From: Kate Giddings <kate.giddings@arun.gov.uk>
Sent: 09 July 2020 16:32
To: Amy Myer <Amy.Myer@arun.gov.uk>
Cc: Planning.Responses <Planning.Responses@arun.gov.uk>; Chantelle Bashford <Chantelle.Bashford@arun.gov.uk>
Subject: LU/163/20/PL - 6 Selbourne Place, Littlehampton, BN17 5NH

In relation to the above application, please may EH comment with the following suggested conditions:

drawing title
Proposed Plans
-
PLANNING

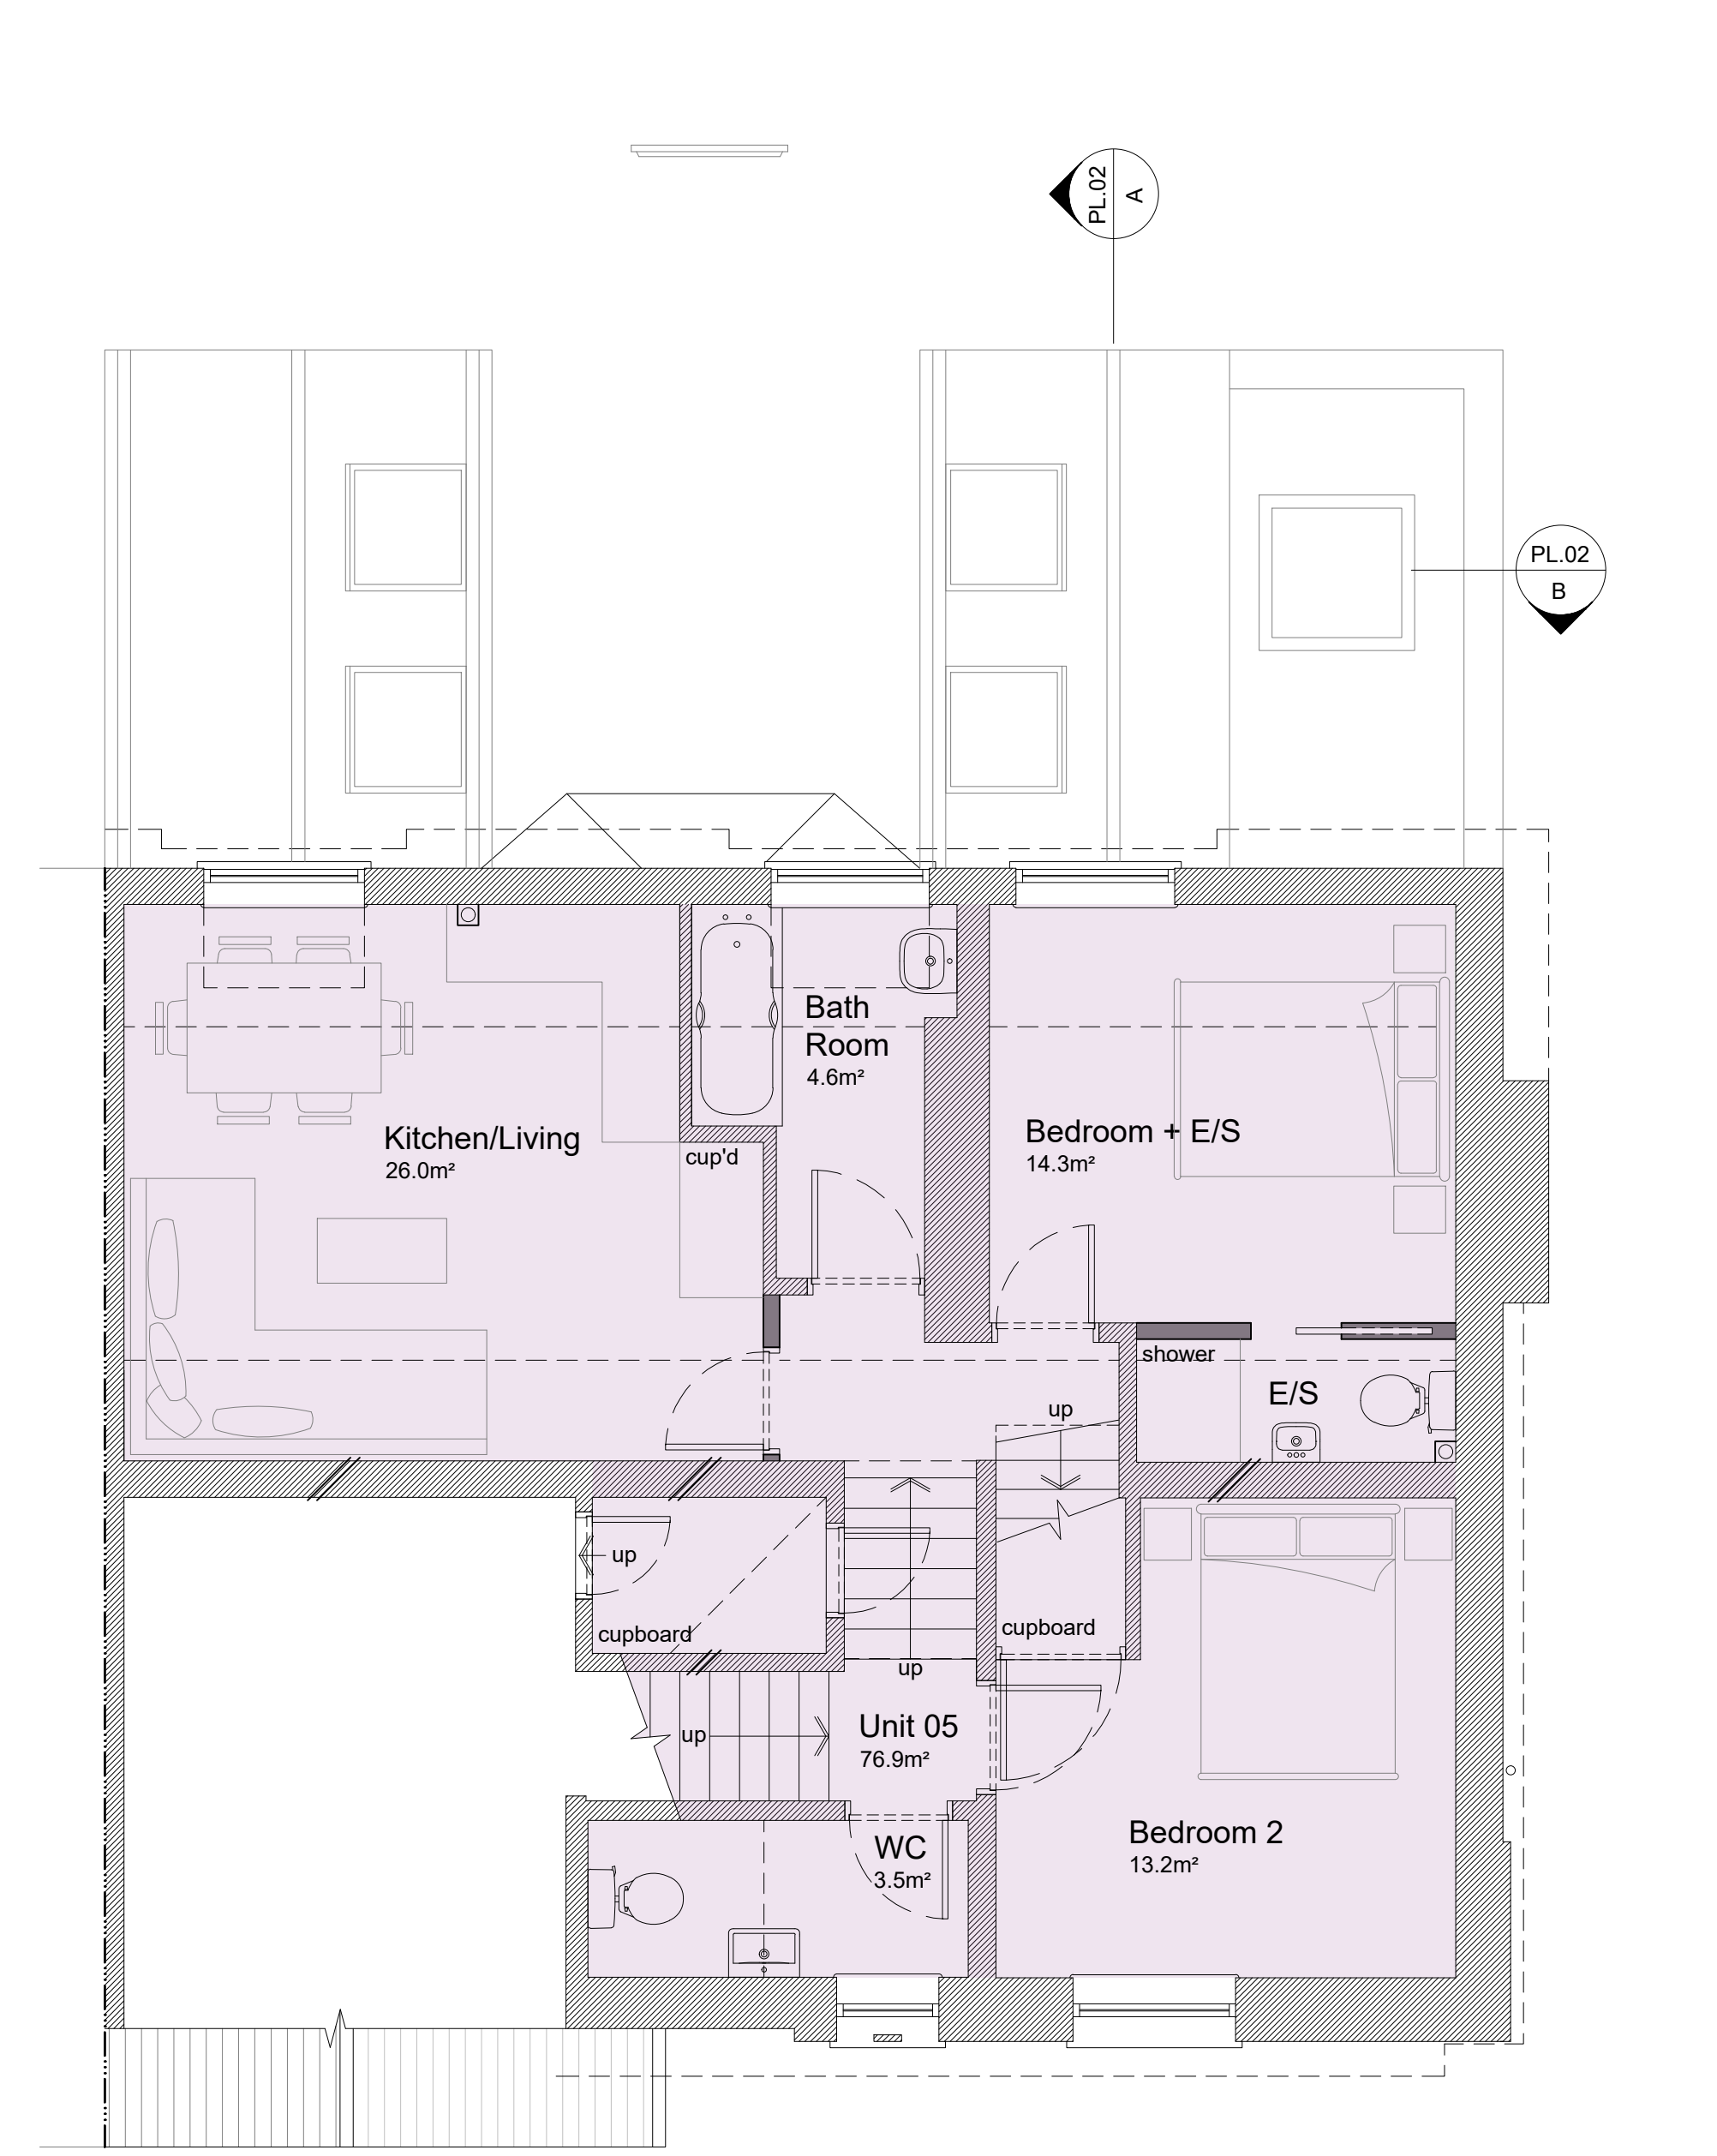
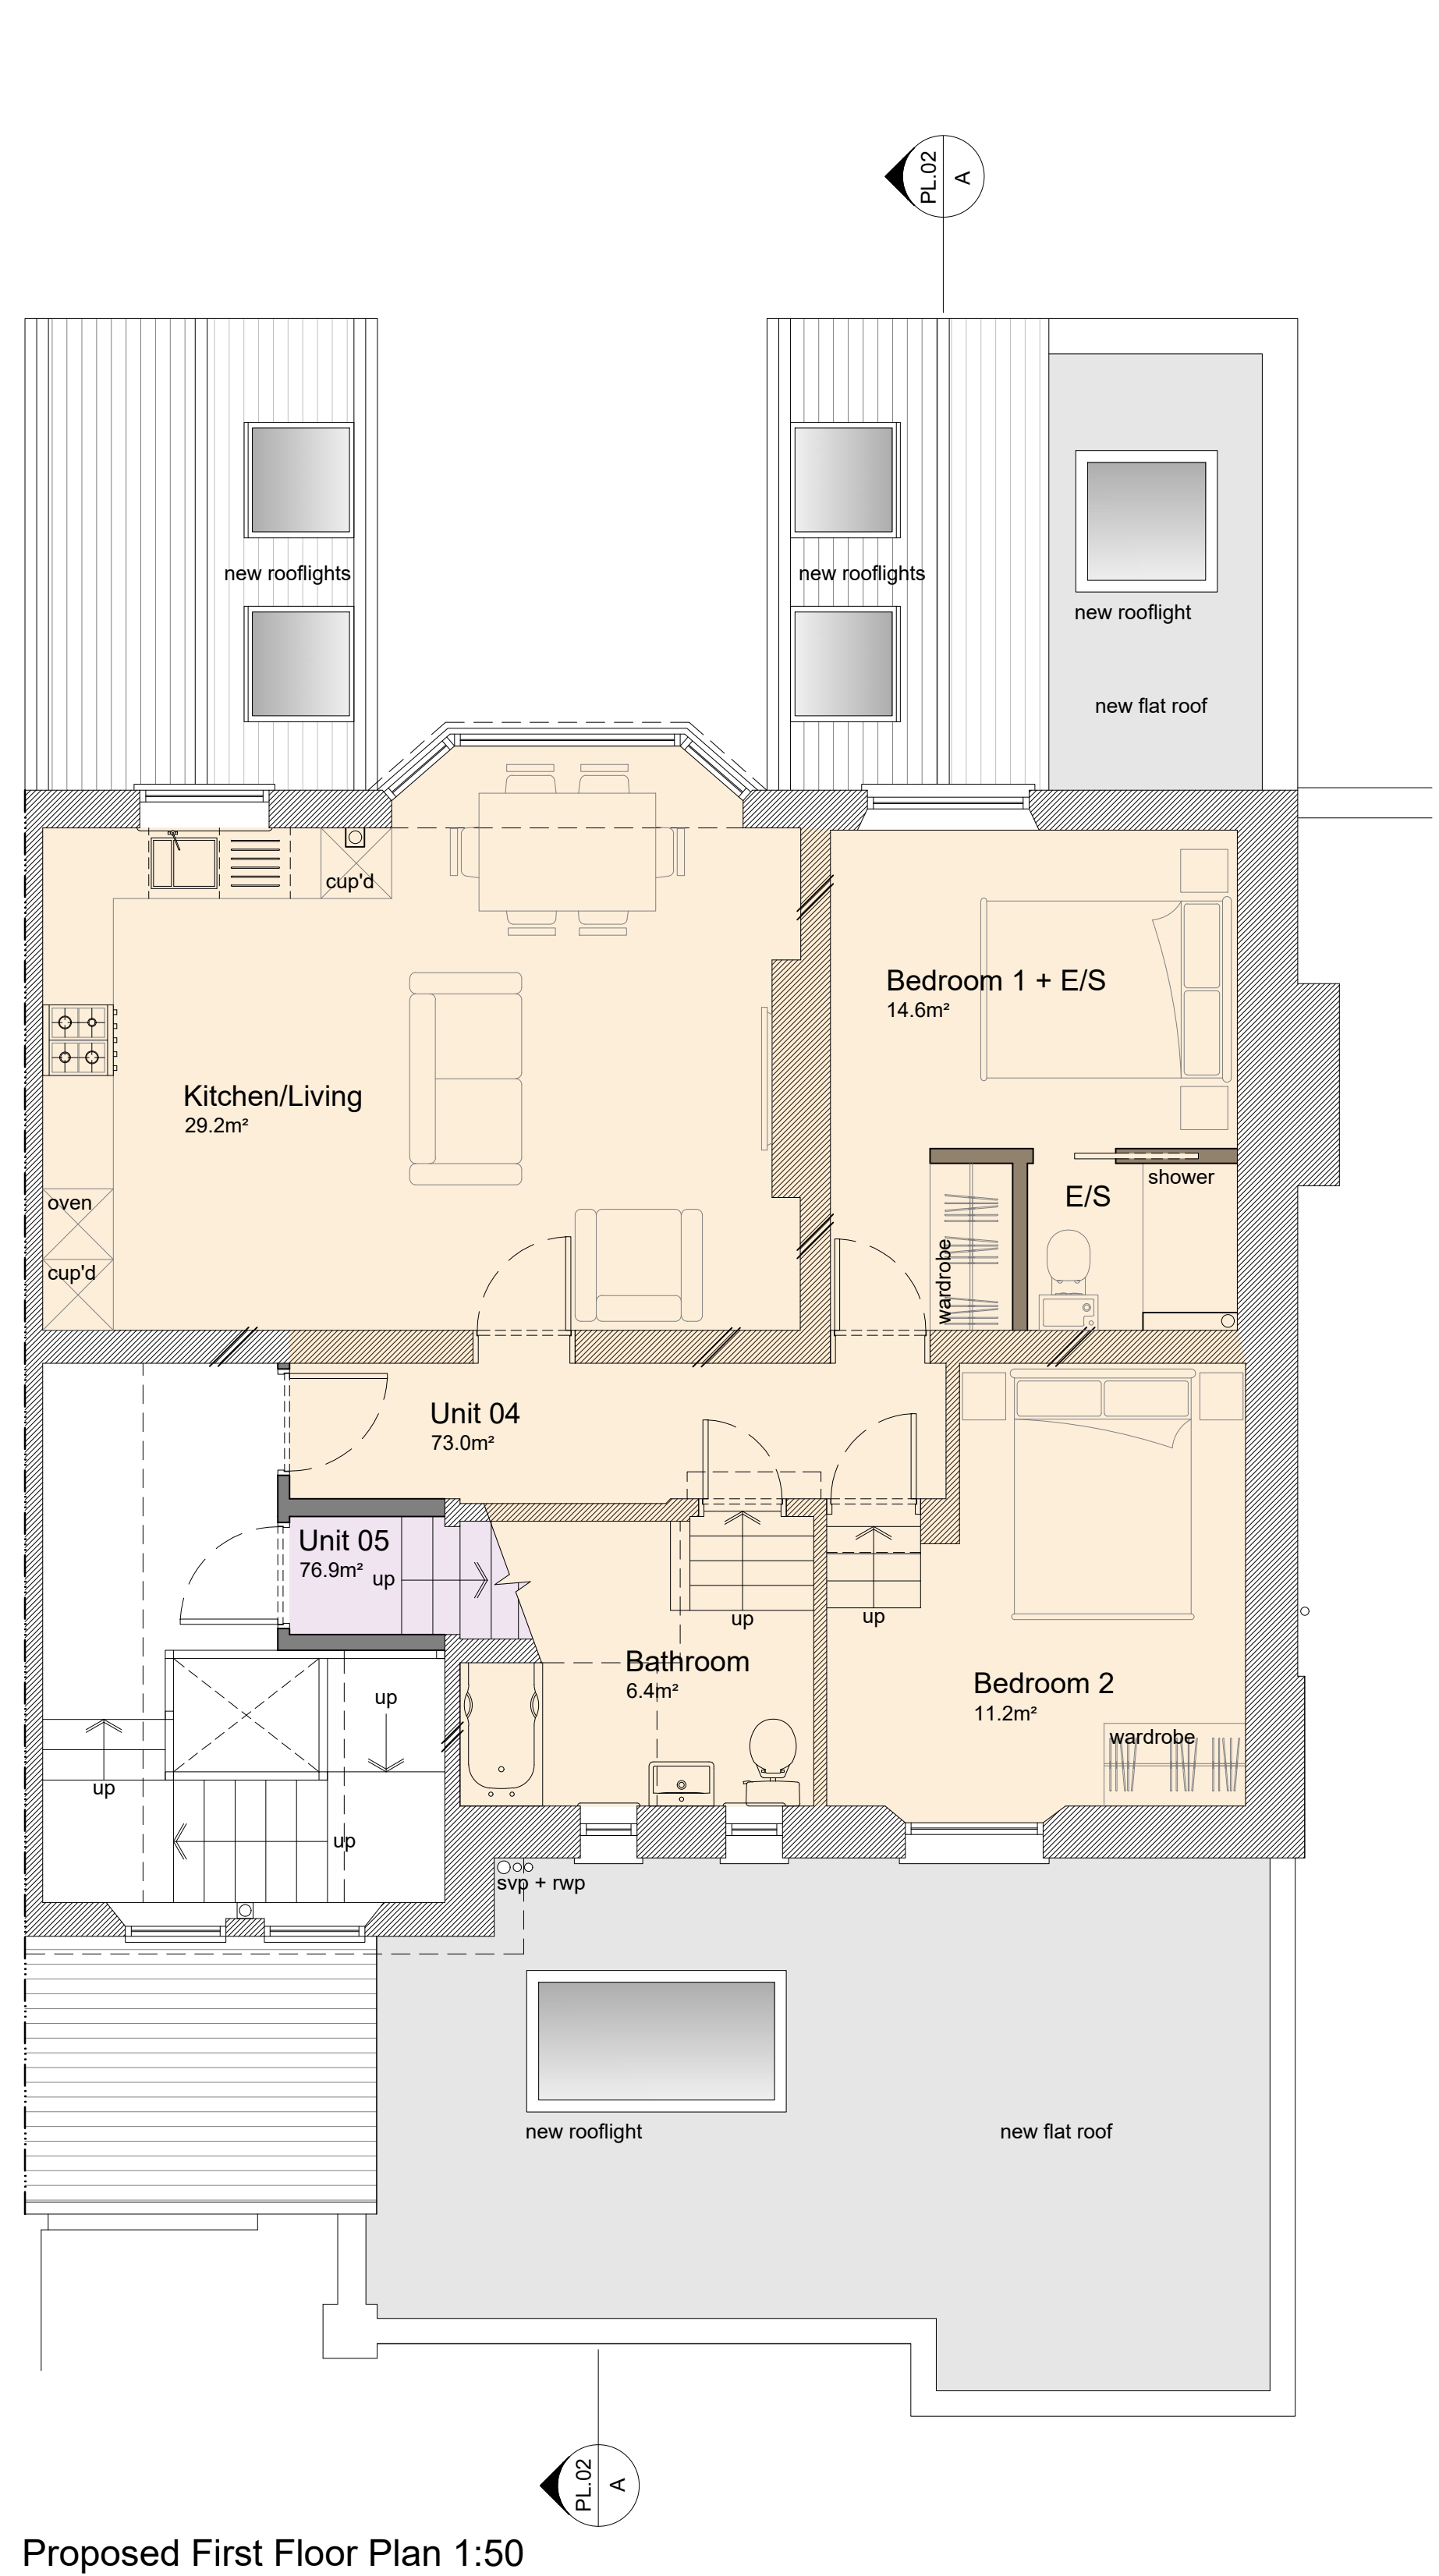
With regard to the proposed internal layout of the building, there are concerns regarding noise propagation between the units, specifically between:

1. the bedroom of Unit One and the overlying kitchen/living space of Unit 4;
2. the kitchen of Unit Two and the overlying bedroom with *en suite* of Unit 4.

It is therefore recommended that the following condition be applied:

- Prior to the commencement of the development hereby approved, a scheme to demonstrate that the internal noise levels within the residential units will conform to the 'Indoor ambient noise levels for dwellings' guideline values specified within Table 4 under section 7.7.2 of BS 8233:2014 and shall be complied by a competent acoustician on sound insulation and noise reduction for buildings and shall be submitted to and approved in writing by the Local Planning Authority. The scheme should take into account the correct number of air changes required for noise affected rooms. The works specified in the approved scheme shall then be carried out in accordance with the approved details prior to occupation of the premises and be retained thereafter. **Reason:** To protect the amenity of local residents in accordance with Policy QE DM1 of the Adopted Arun Local Plan 2011 – 2031.
